Pascal VanDeWalle - RE: Oakdale Central (Goodmans)

From: Greg Paine <greg.paine@trade.nsw.gov.au>
To: Pascal VanDeWalle <Pascal.VanDeWalle@planning.nsw.gov.au>
Date: 19/12/13 1:45 PM
Subject: RE: Oakdale Central (Goodmans)
CC: <wayne.jones@trade.nsw.gov.au>

Comment by NSW Office of Water

Title: **OLD WALLGROVE ROAD UPGRADE GENERAL ARRANGEMENT PLAN**

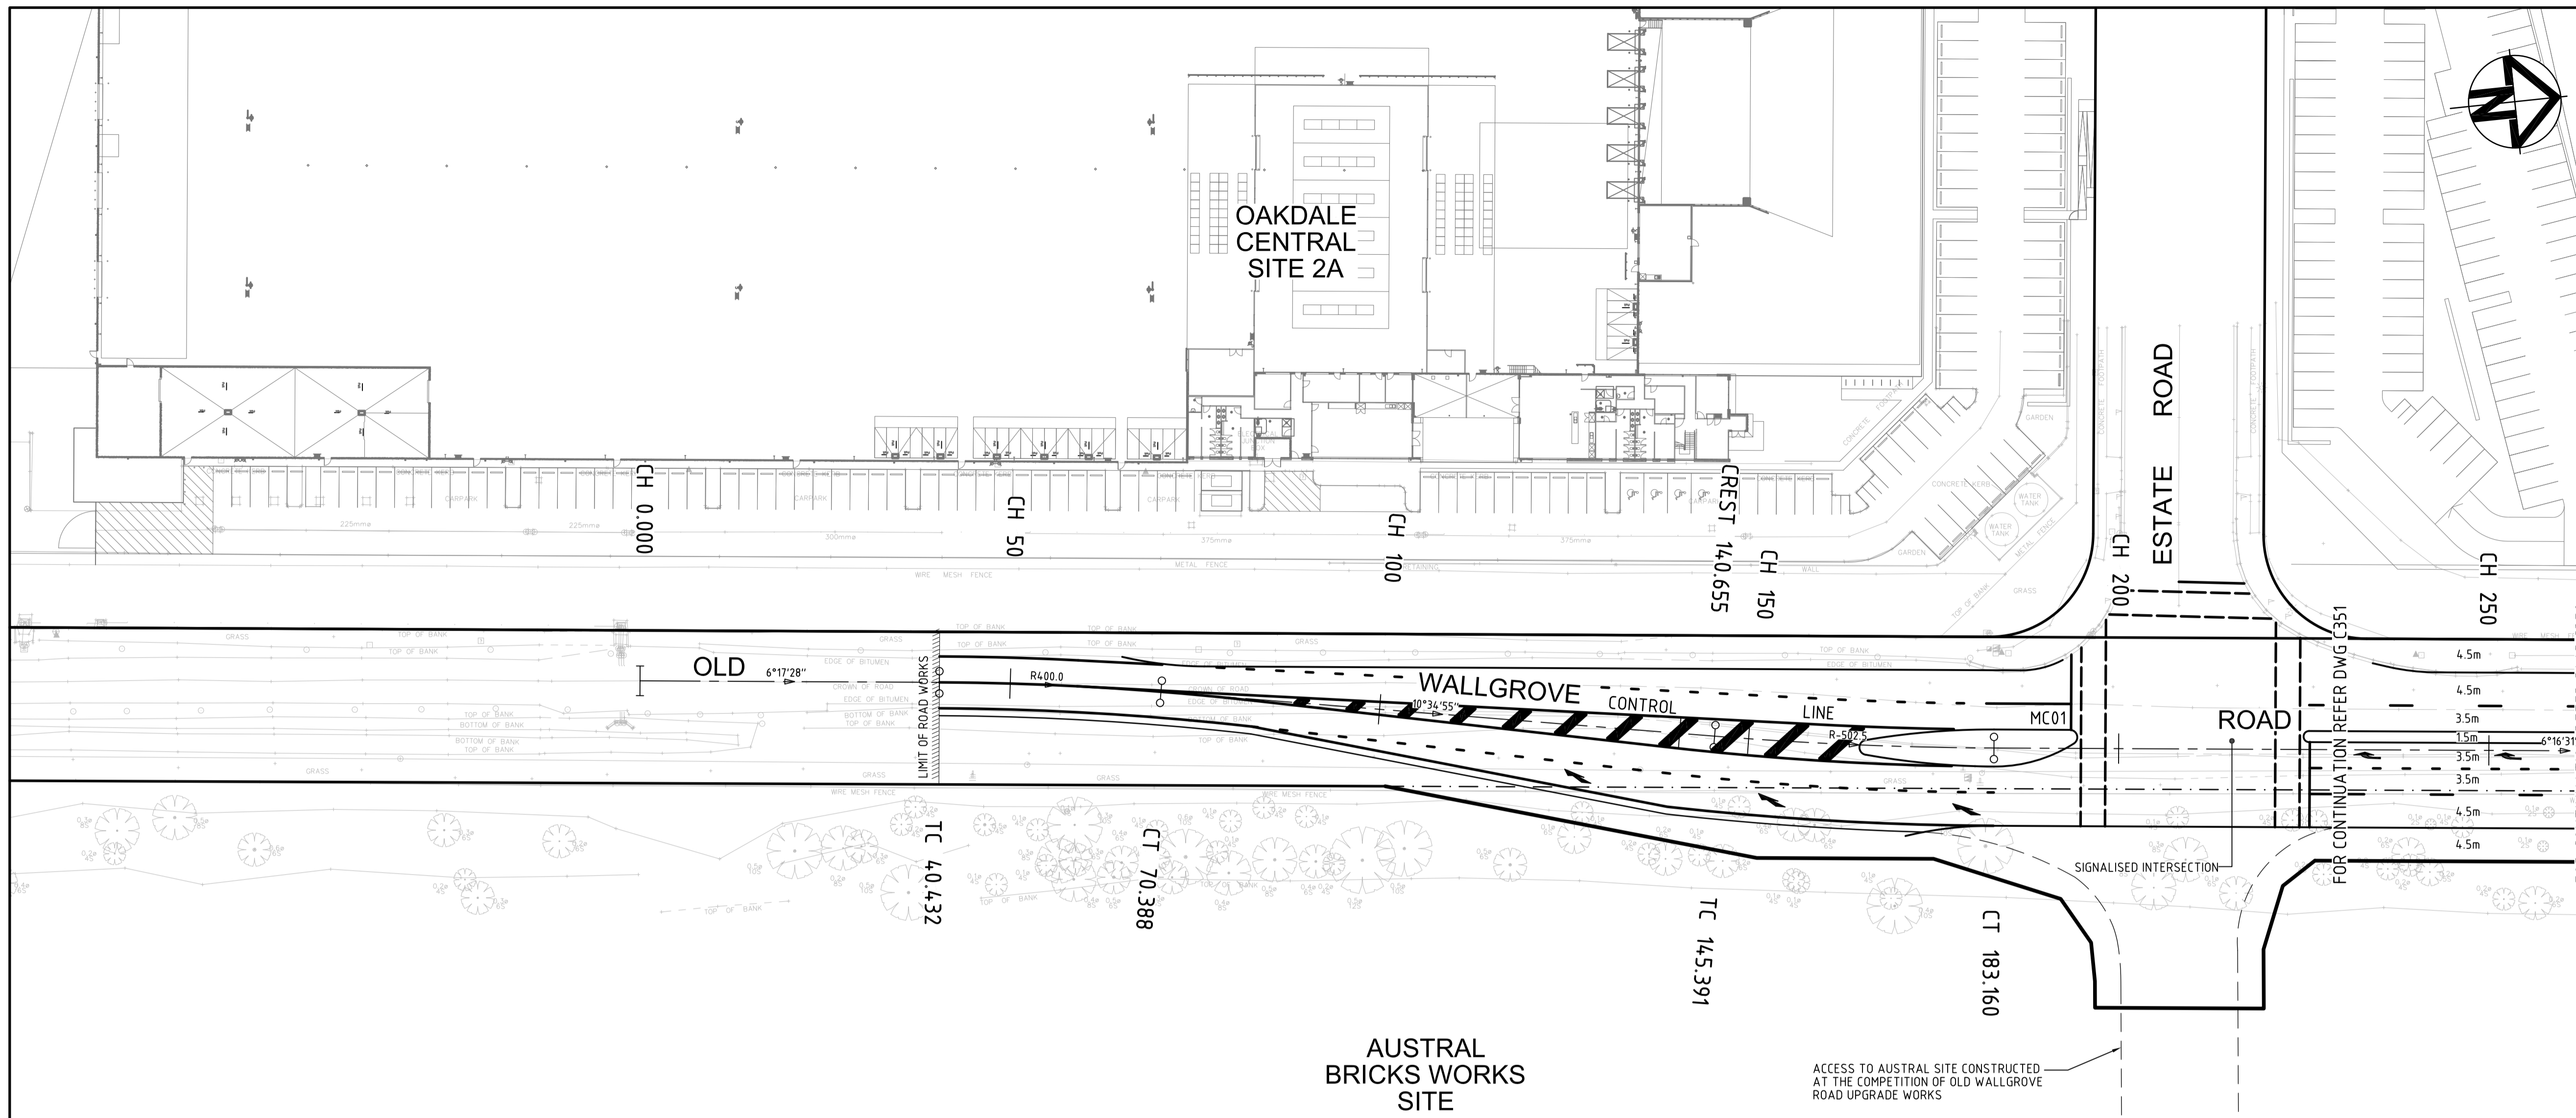
Crown Lands advise:

- (i) the site is bounded on the east (Old Wallgrove Road) and partly on the south by public roads which are Crown roads.
- (ii) it is noted the proposal involves the construction of part of these roads to facilitate vehicular access to the development.
- (iii) any such works will require the approval of Crown Lands. In this regard, Crown Lands will require that the roads be transferred to the control of the local council, under the provisions of Section 151 of the *Roads Act 1993*, prior to the commencement of any works to construct the roads.
- (iv) Crown Lands is able to gazette such transfer on receipt of a letter from the council (with a diagram identifying the affected roads) agreeing to accept the transfer.
